**HOUSING & PLANNING
SERVICES DEPARTMENT**

Application no: H13/1196/98

Description: Demolish and replace two
storey detached dwelling

Location: 92 Roman Road
Moulton Chapel
Spalding
Lincs

DRG 3^B OF 3

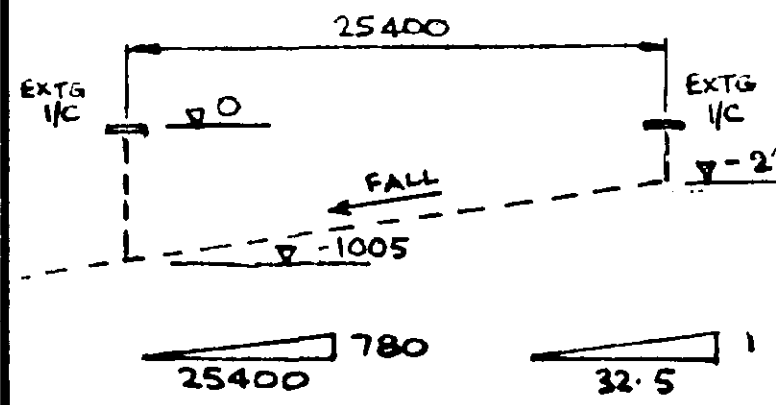
Amendment: Dimension from boundary to front corner of dwelling altered
to 1.7m from existing cistern to back wall

① DIMENSION FROM BOUNDARY TO FRONT
CORNER OF DWELLING ALTERED TO
MAINTAIN 1.7M DIM FROM EXISTING
CISTERN TO BACK WALL

The building is going further back and will ^{so} have less impact.
